### **SSD 15\_7155 Prestons Industrial Estate - Response to Submissions**

This letter has been prepared on behalf of Logos Australian Logistics Venture Prestons Trust to respond to the submissions in relation to the exhibition of the State Significant Development Development Application (SSD DA) for the staged construction of five warehouse or distribution centre buildings on land at the corner of Yarrunga Street and Bernera Road, Prestons. The proposal was on exhibition from 10 March to 12 April 2016.

SWEPT PATH ANALYSIS OF A 19m ARTICULATED VEHICLE EXITING THE SITE

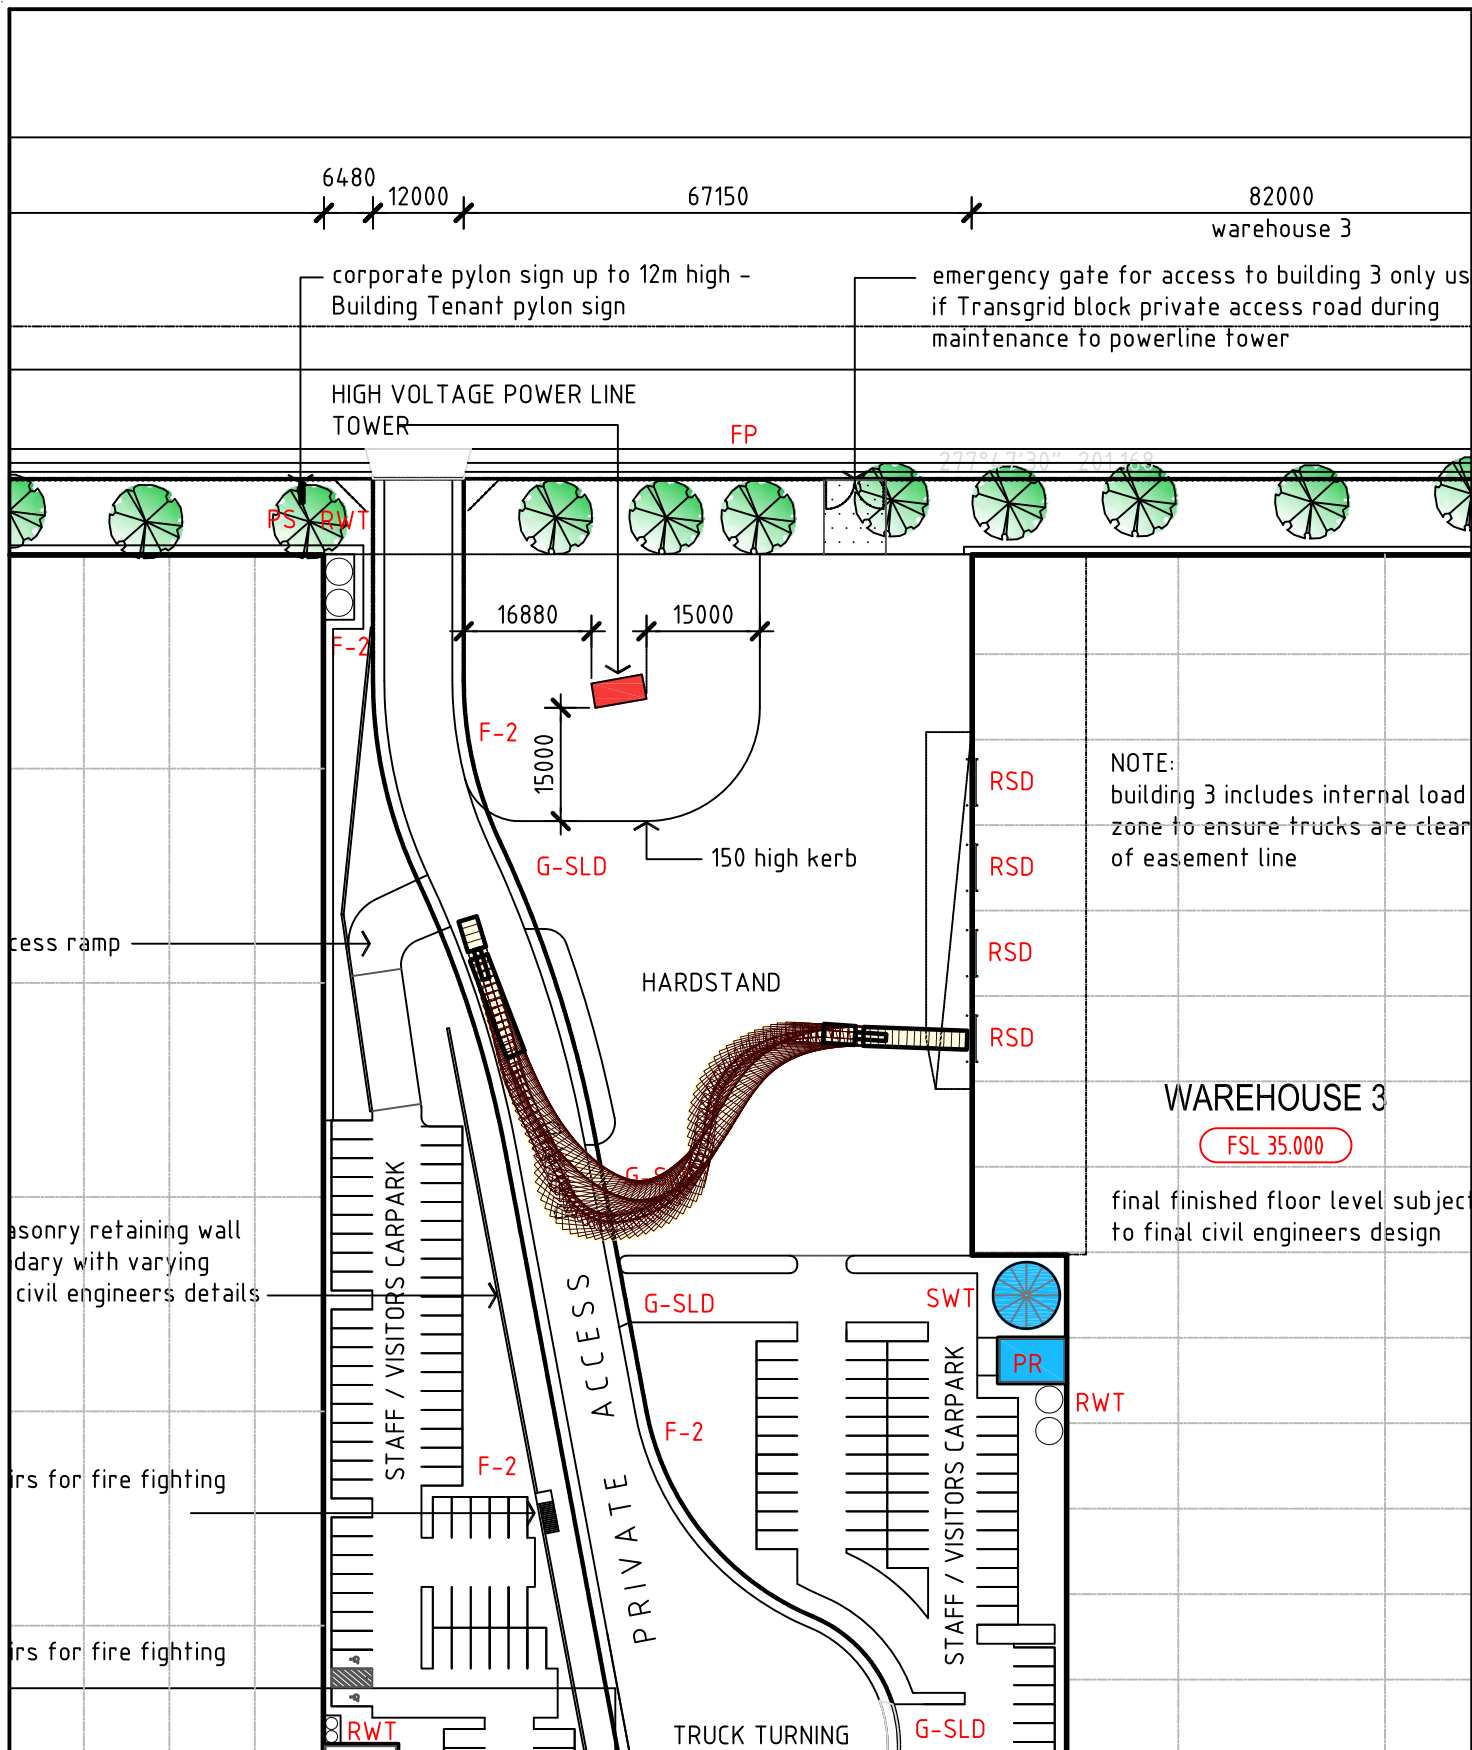
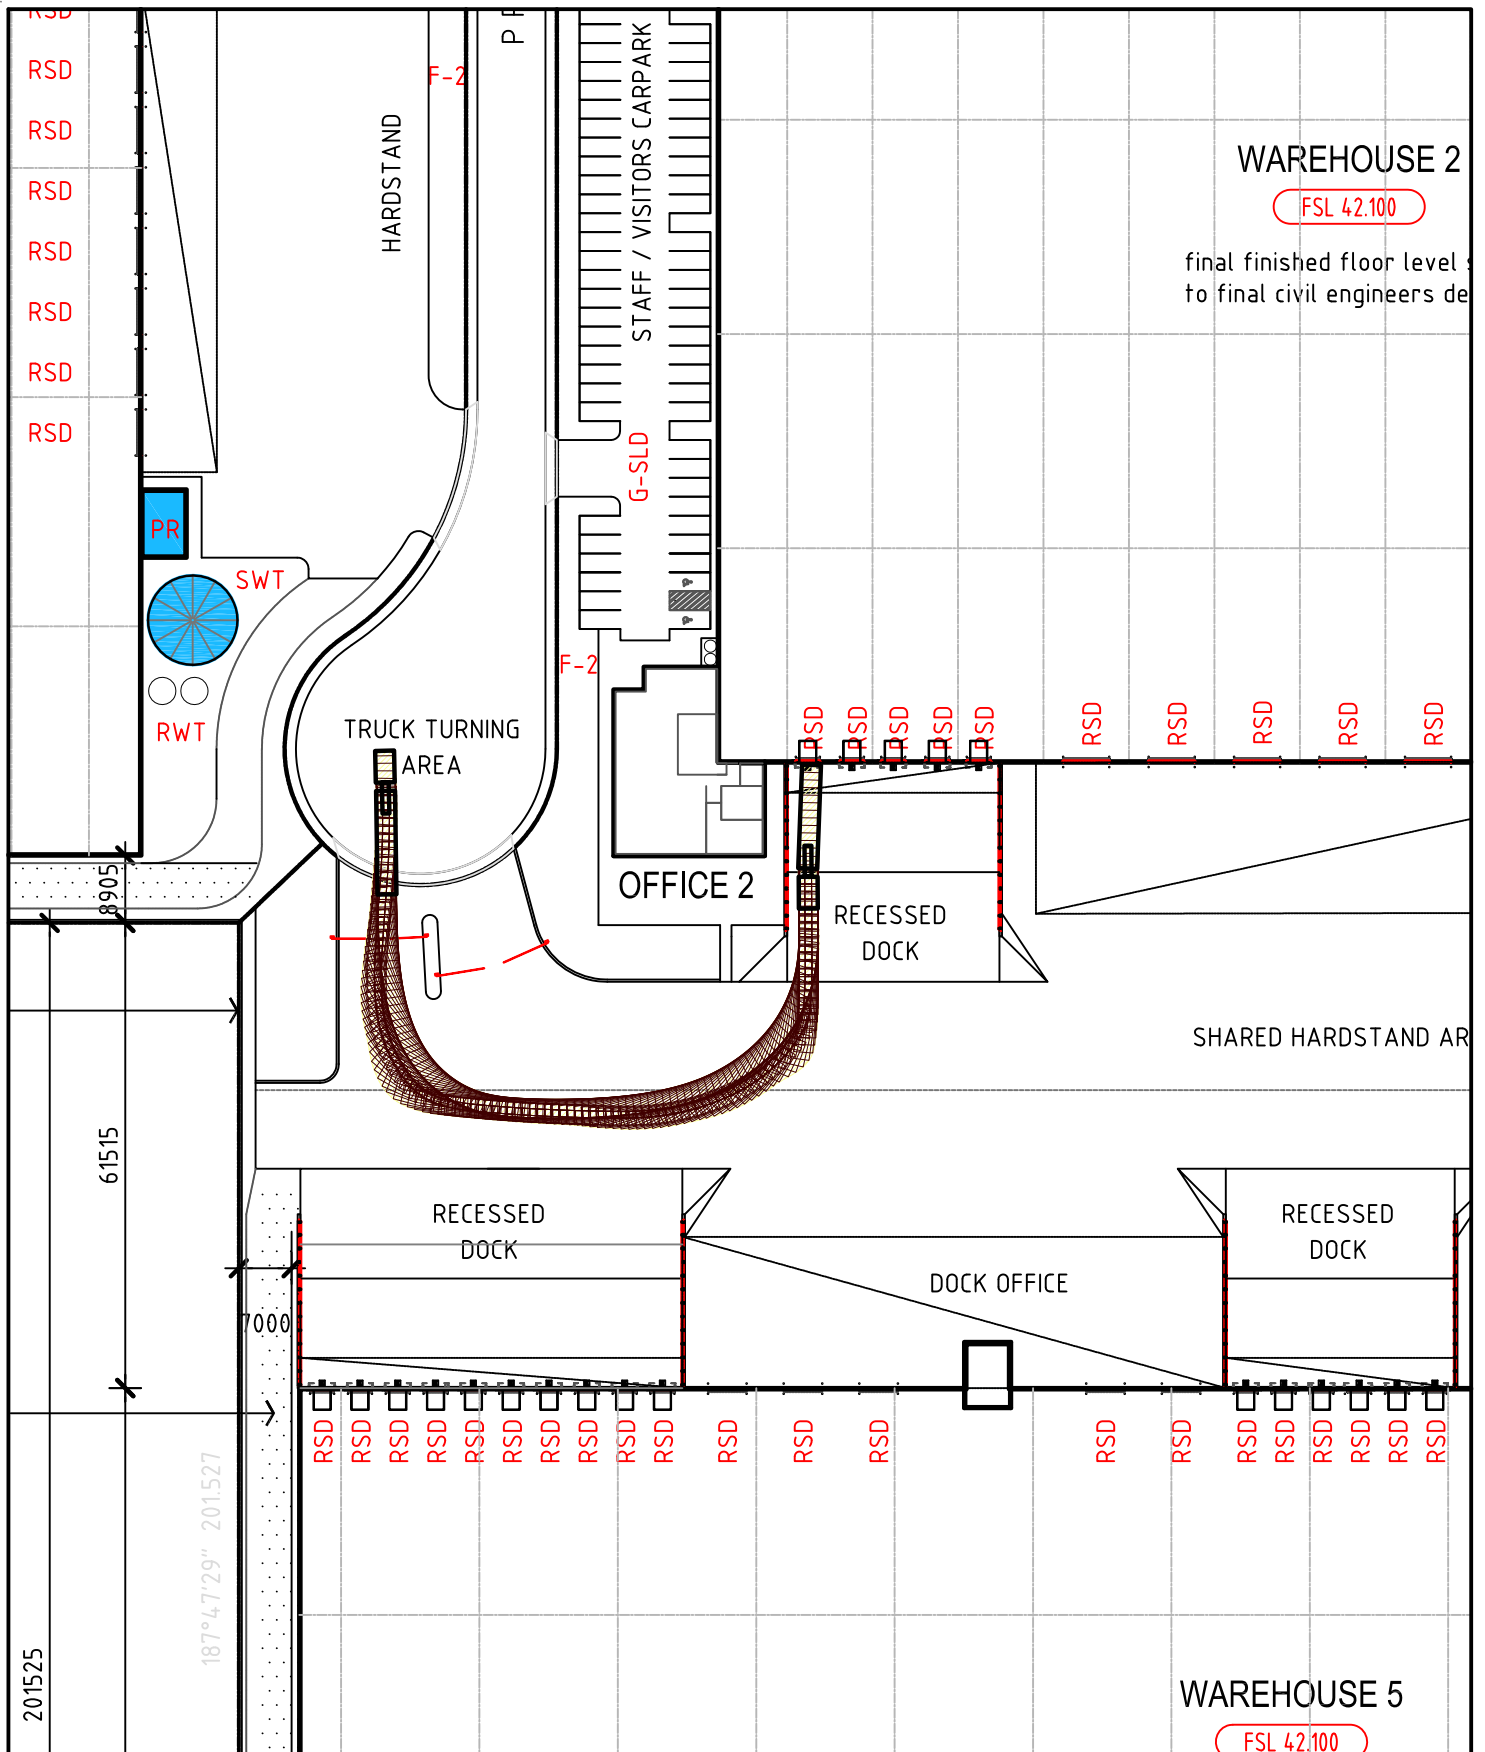
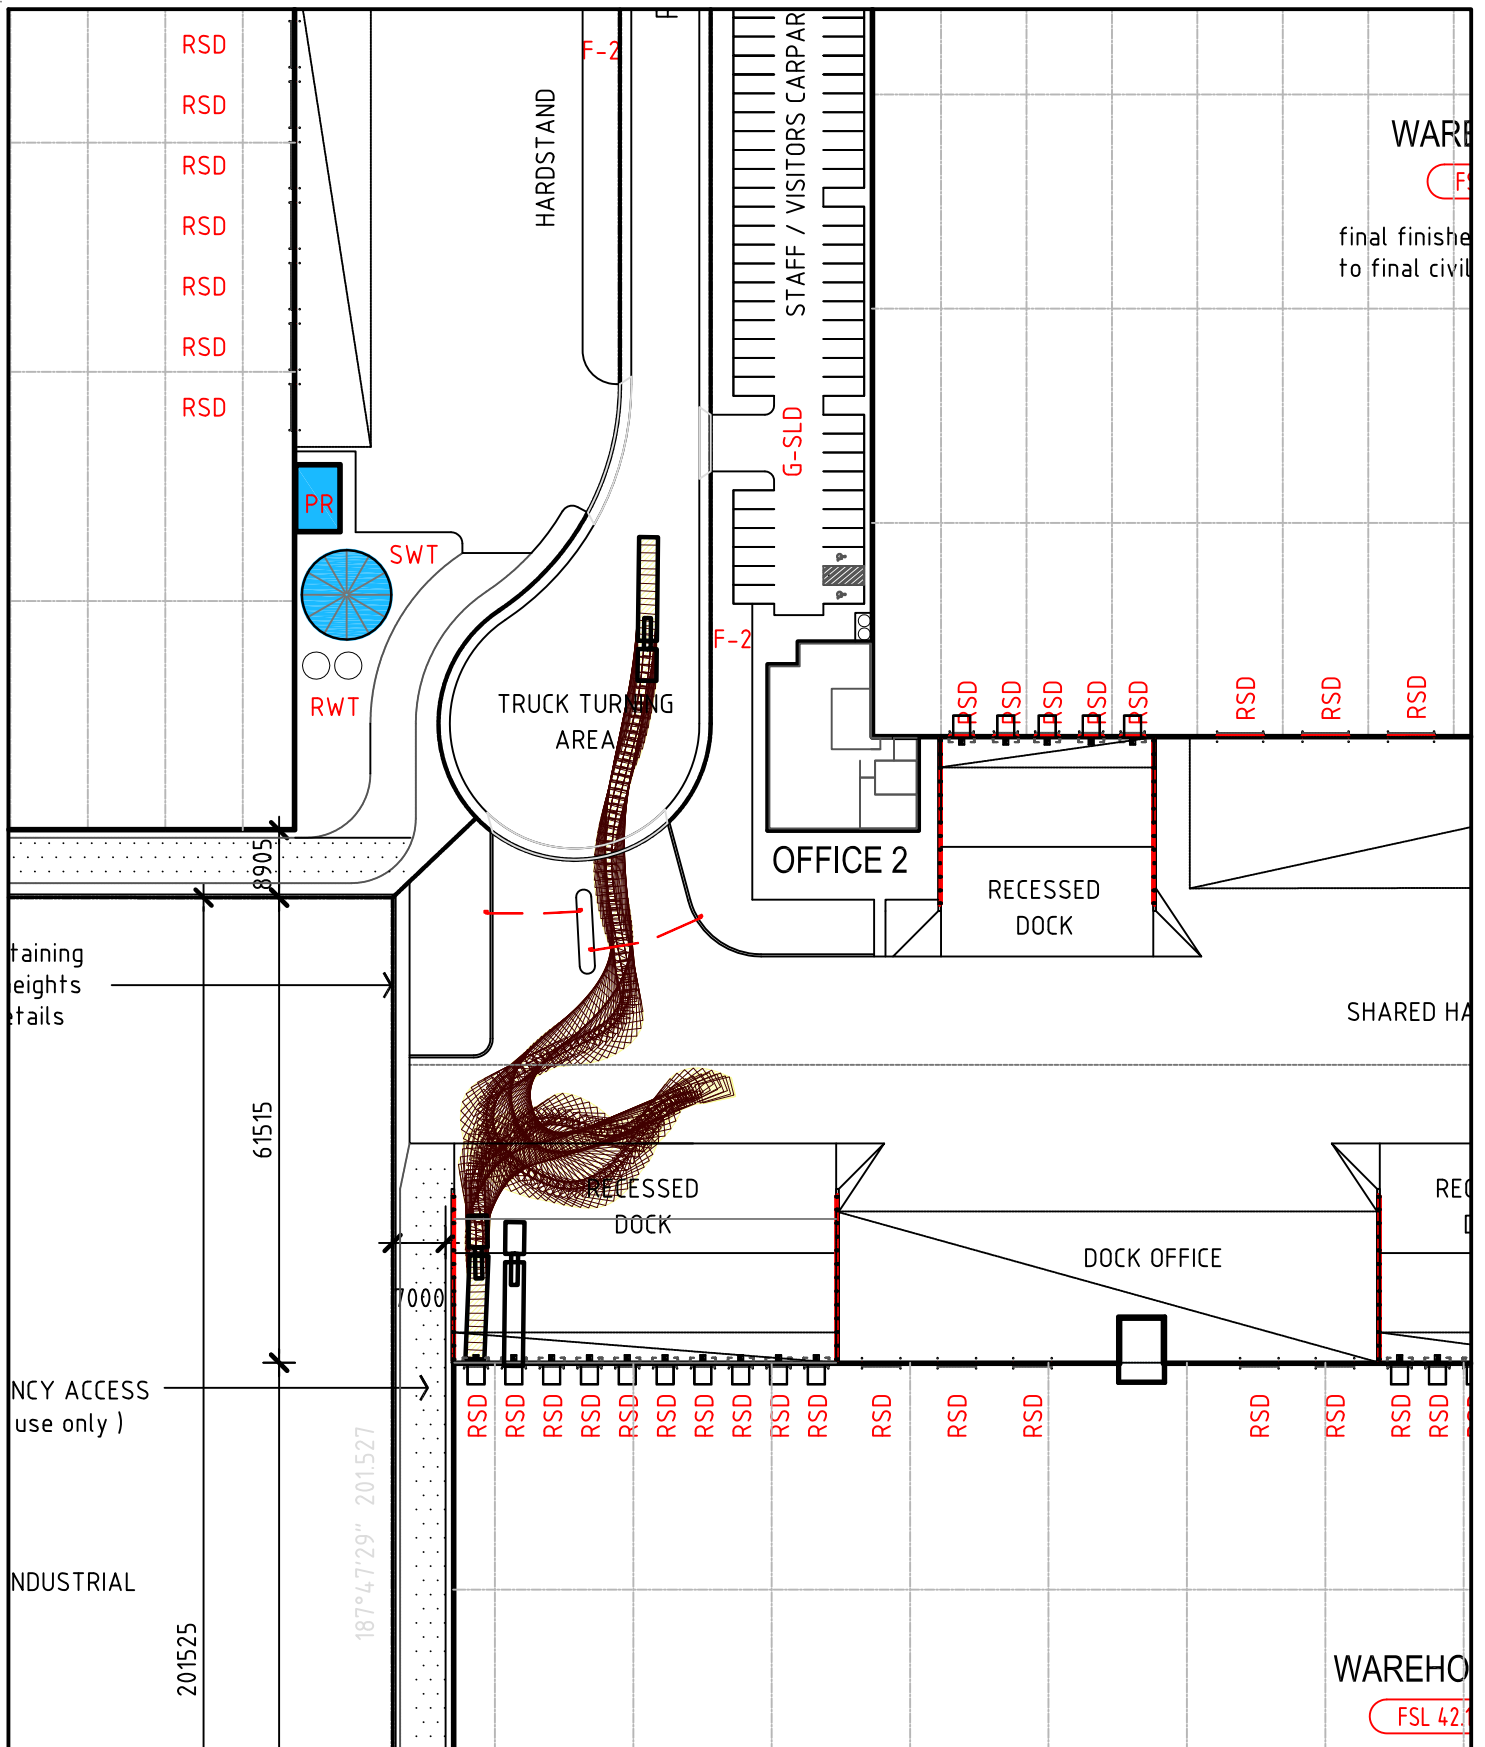
| SUBMISSION  | RESPONSE  |
|---|---|
| <p><b>Roads and Maritime Services</b></p> <p>1. It is advised that a 26m B-double truck should be used as a design vehicle for the extent of works required on the intersection. The swept path plan should be modified showing turning path of a 26m B-double on the south western corner of the intersection to cater for the left turn movement of articulated vehicles accessing the site.</p> <p>2. A large number of 19m semi-trailers access the Aldi warehouse located east of the site via Yato Road. In this regard, swept path plans should be provided and submitted for review showing that the signals will operate as a double diamond</p>   | <p>The applicant accepts the requirements of RMS and that conditions shall be added to this effect.</p> <p>Given that RMS will require a WAD (and bearing in mind that Council are asking for revisions to the intersection), the applicant suggests that all the design parameters can be covered during detailed design in the WAD process and thus signed off by RMS in the WAD.</p>   |

**EAST ELEVATION
WAREHOUSE 5**
1: 400 scale

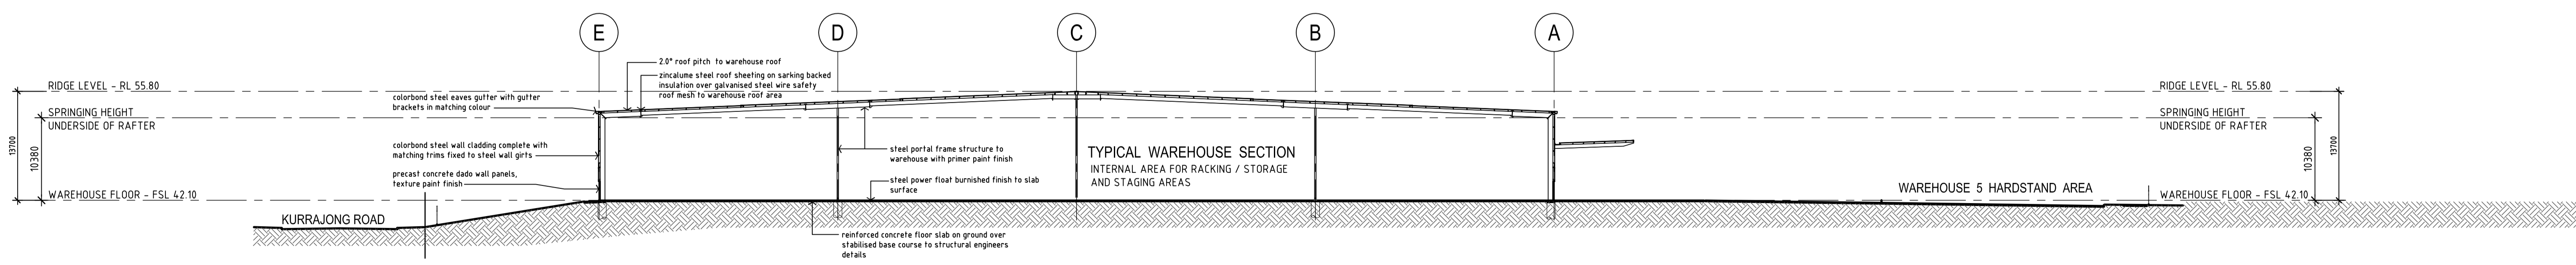
- External substations at the eastern elevation of Warehouse 5.
- Provision of larger outdoor space for staff at Warehouse 5.
- The recessed dock of Warehouse 2 is split to improve functionality.
- Removal of driveway at Warehouse 4 and median strips on Bernera Road.
